Roadway Plans_V1.pdf Markup Summary

CLEARWAY FILING NO. 2, LOT 5

CONSTRUCTION PLANS

**STORM 6 STA 0+93.19 TO STA 1+61.31**

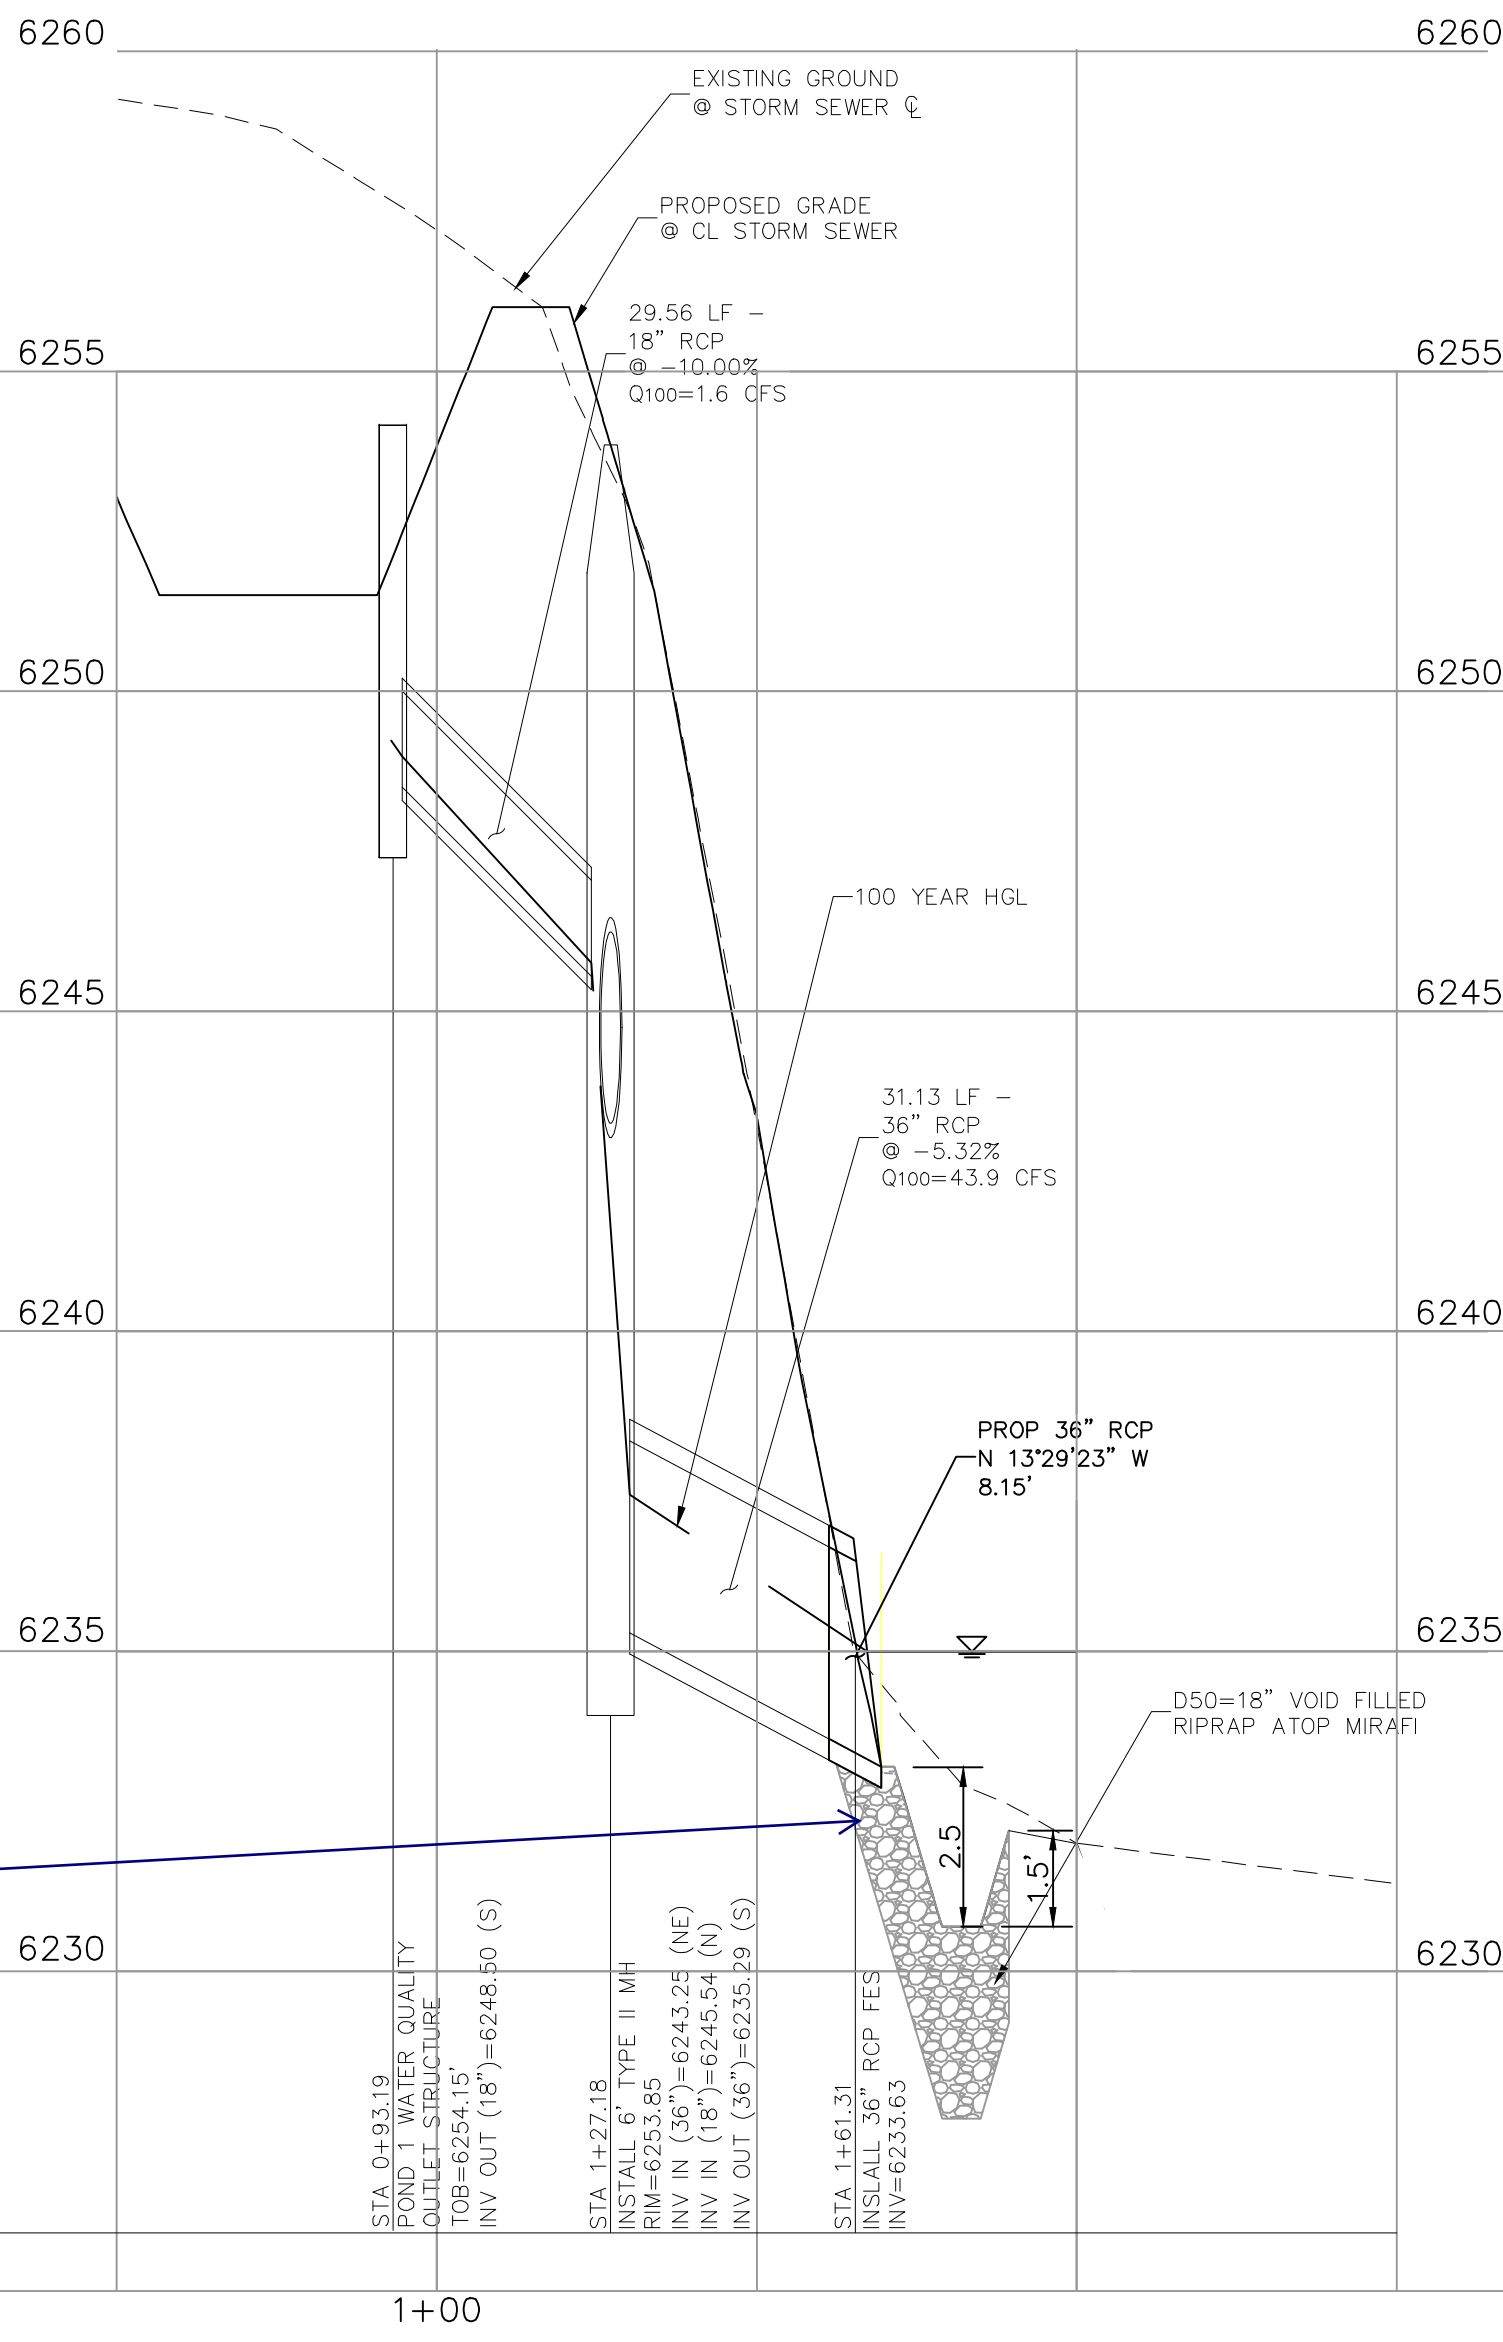
Show HGL lines on the profiles.

18" identified on the drainage plan. Revise accordingly.

identify the cut-off wall indicated in the GEC plan
